Arun District Council
Arun Civic Centre
Maltravers Road
Littlehampton
West Sussex BN17 5LF
Planning & Building Control General
Enquiries
Tel: (01903) 737756 Fax: (01903) 730442
Dx: 57406 Littlehampton
Minicom: 01903 732765
e-mail: planning@arun.gov.uk
website: www.arun.gov.uk/planning
Our Ref: FP/179/11/
Your Ref:

4th October 2011

Demolition of existing dwelling & outbuildings & erection of 6 no. apartments with associated parking & landscaping (re-submission following FP/182/10/)
30 Limmer Lane Bognor Regis

Proposed Apartments
Proposed Elevations

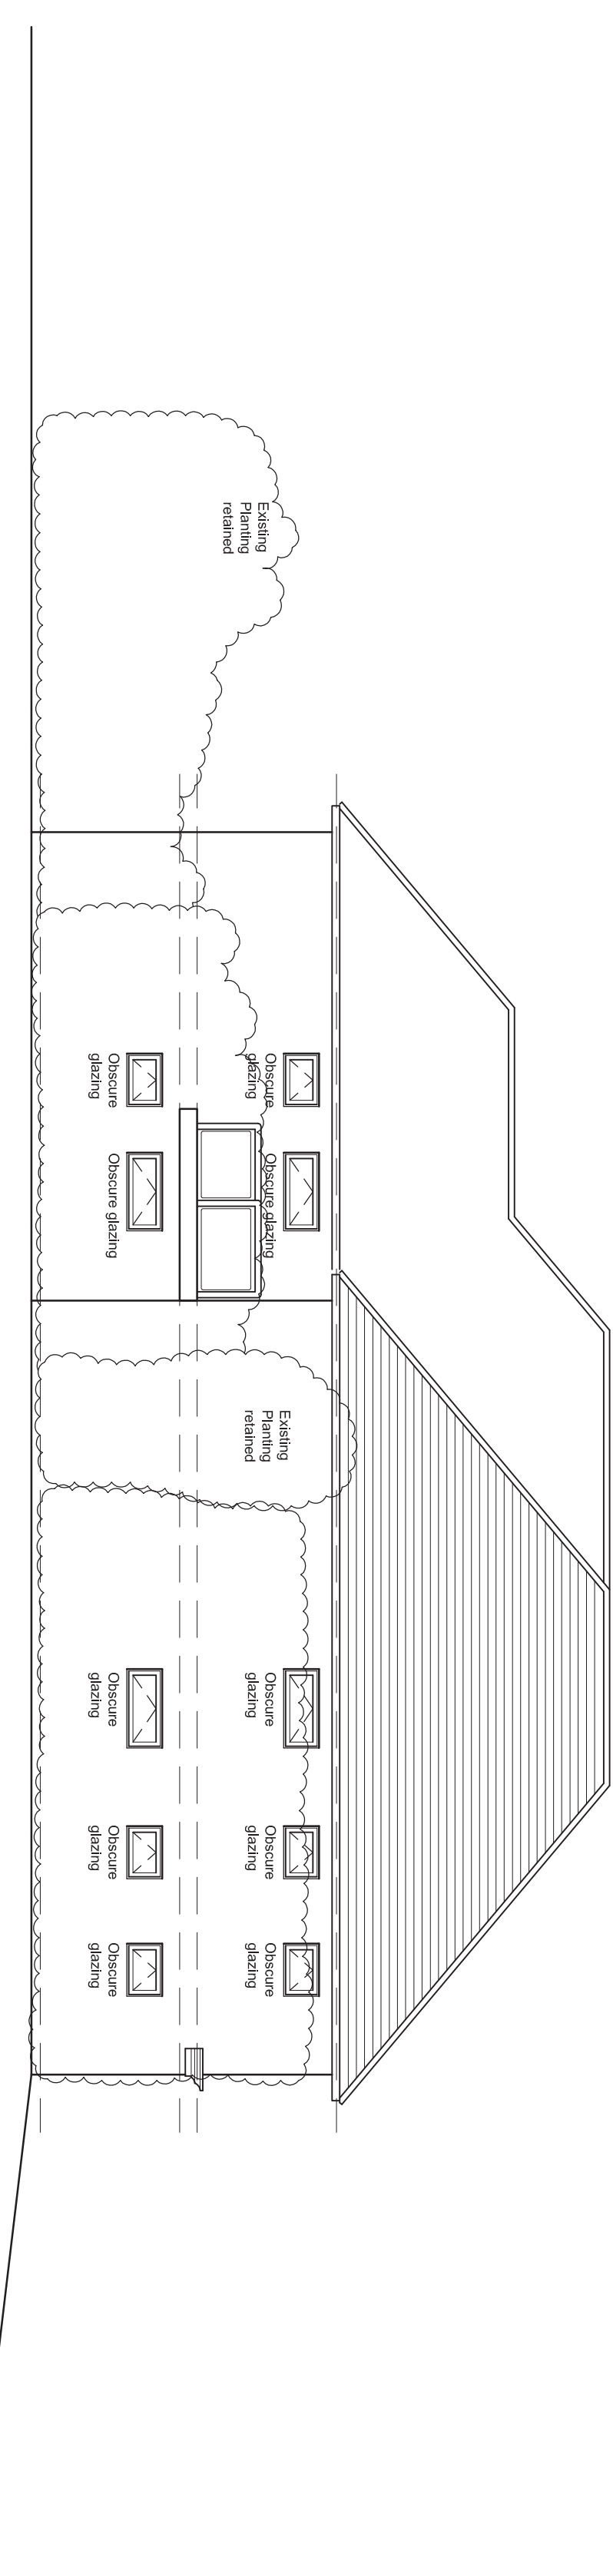
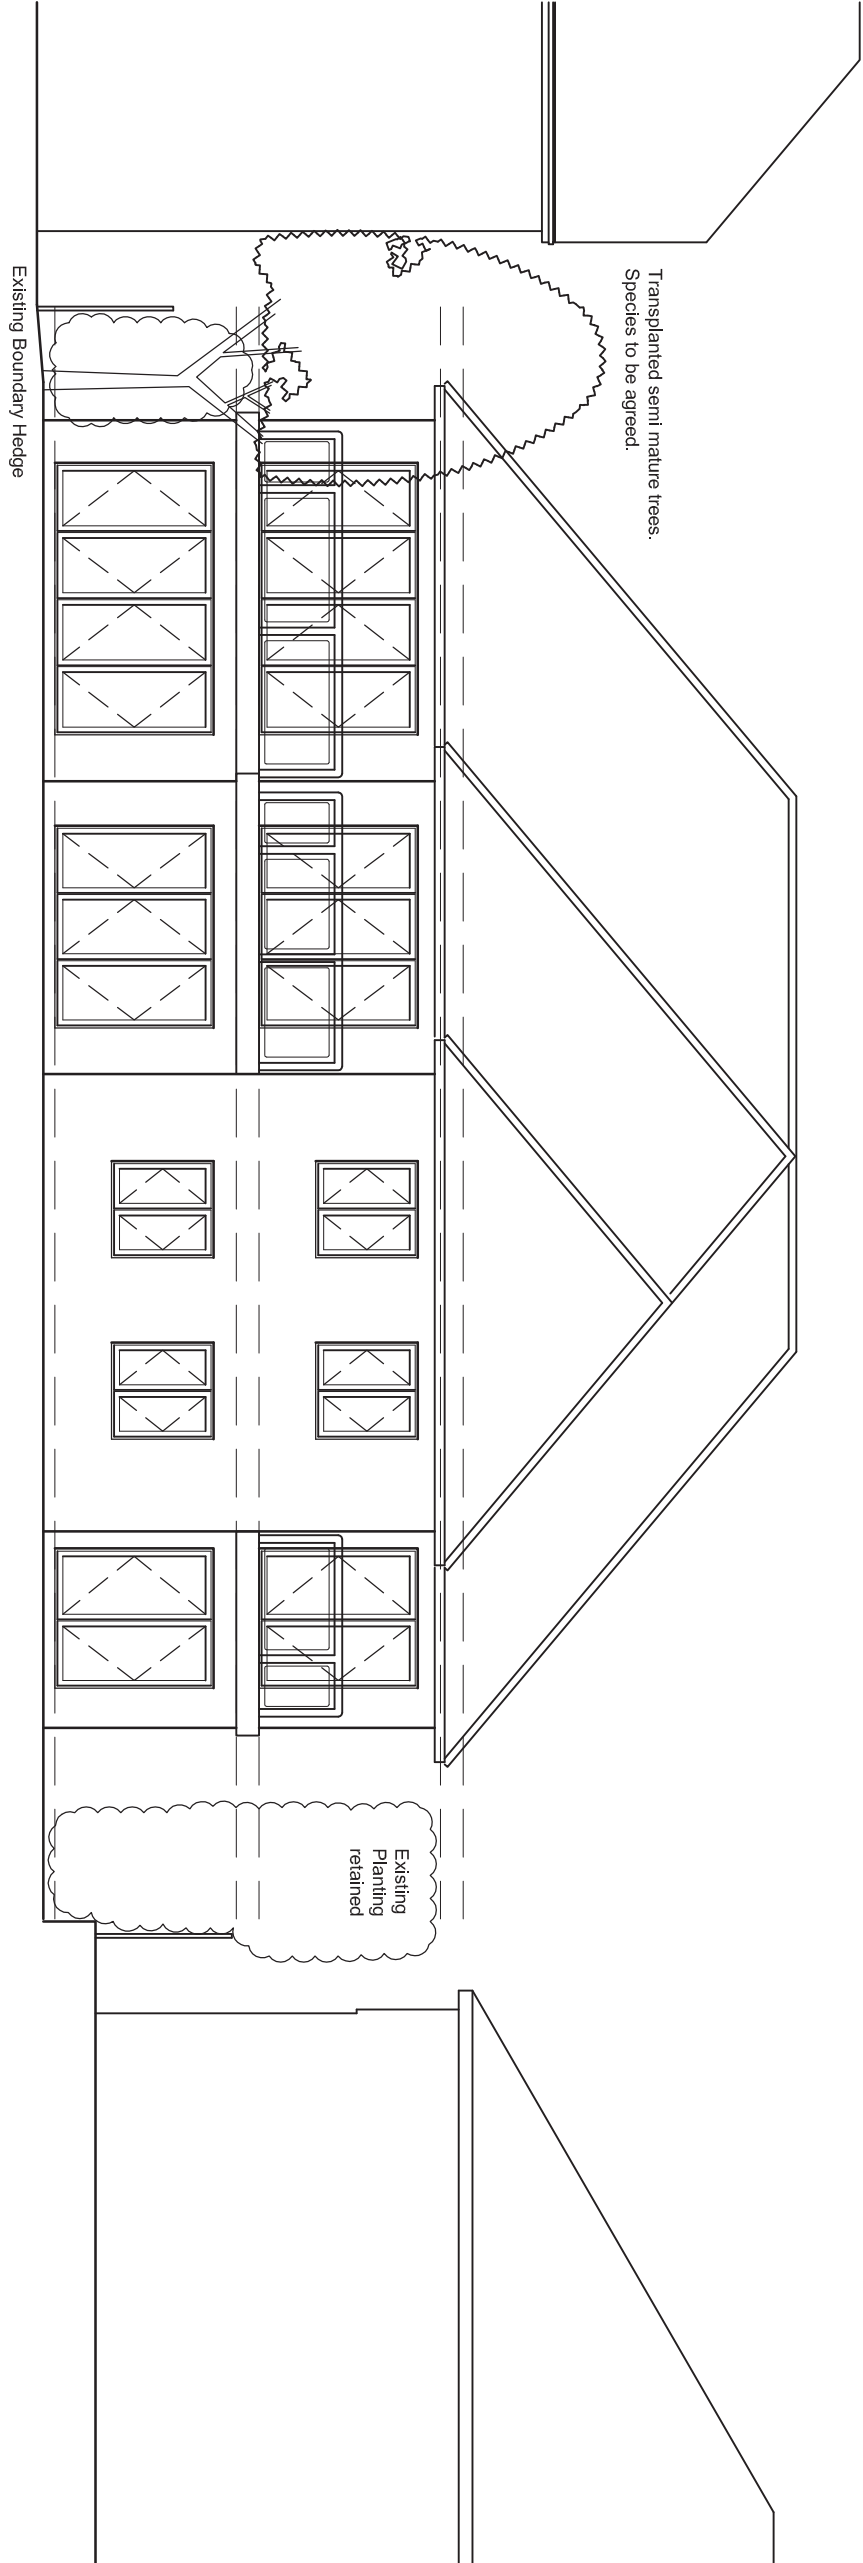
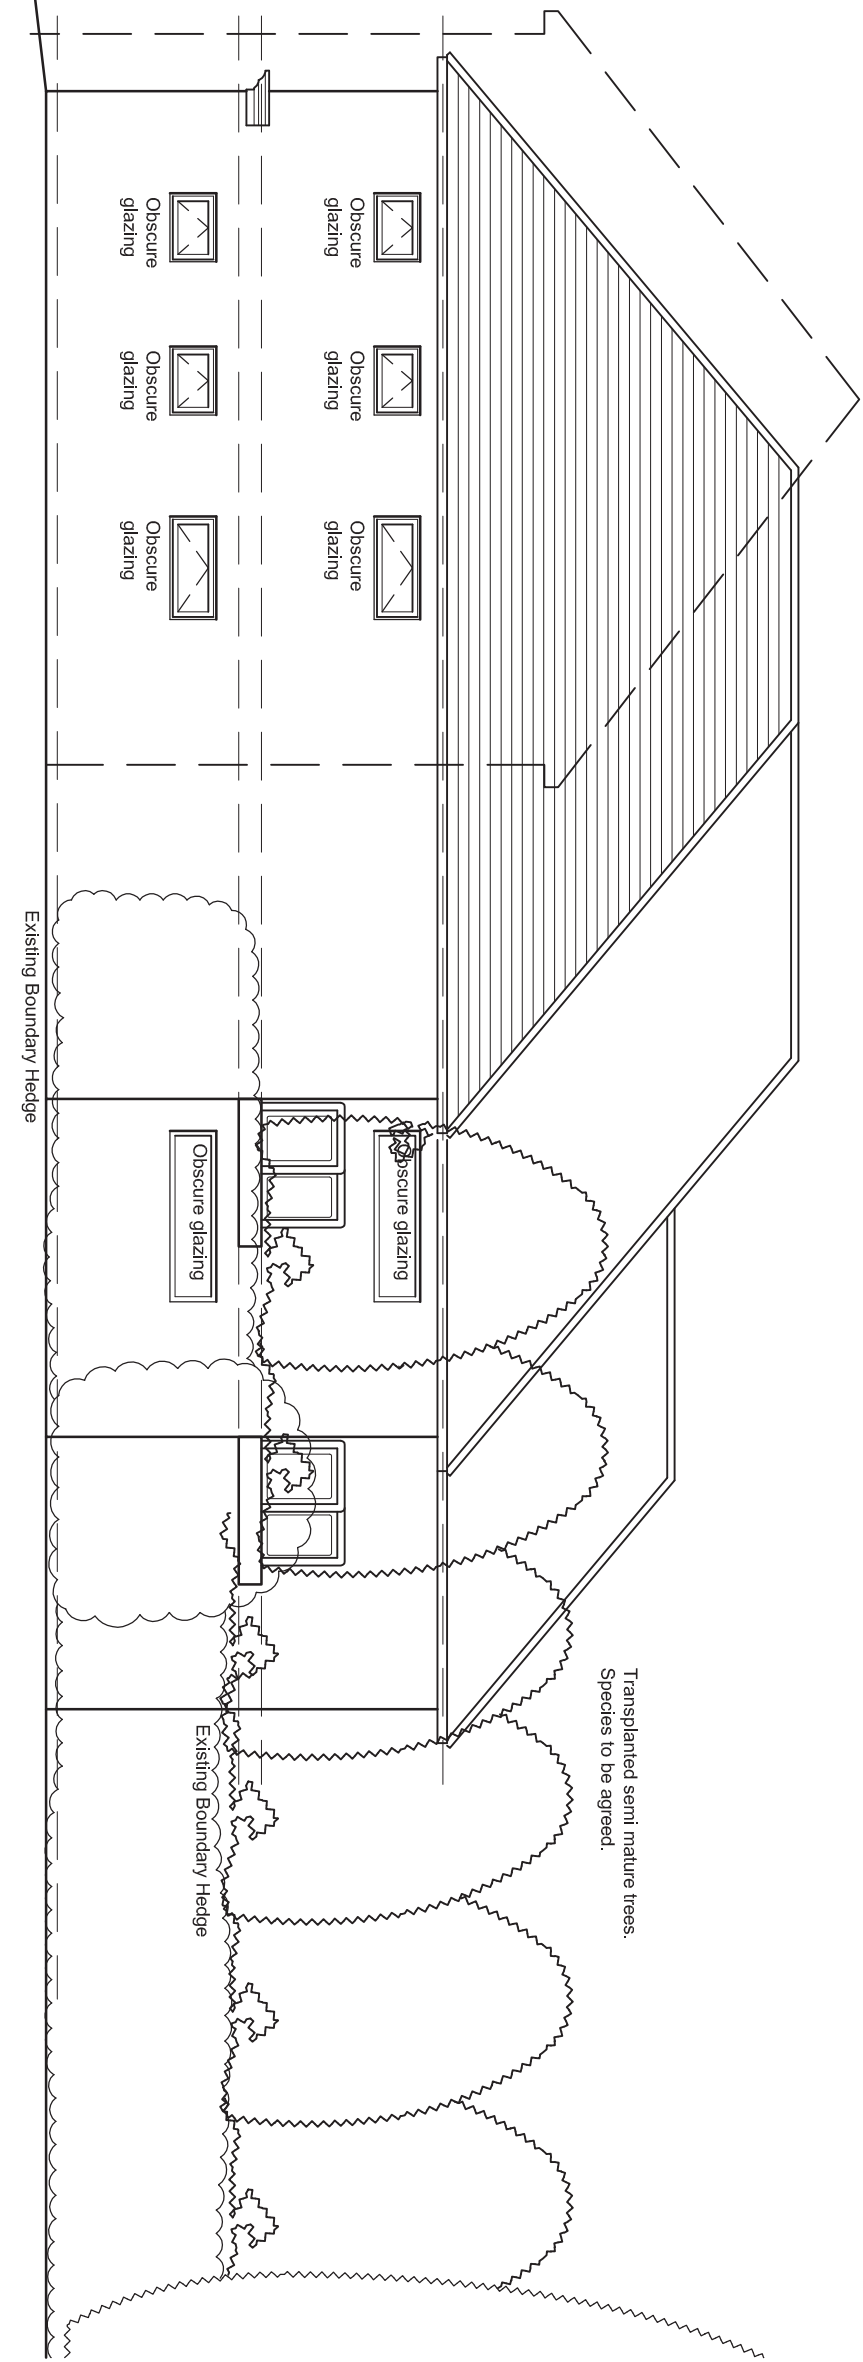
Please provide 1 electronic or 3 paper copies of revised east and west proposed elevations as they do not appear to match the proposed floor plans.
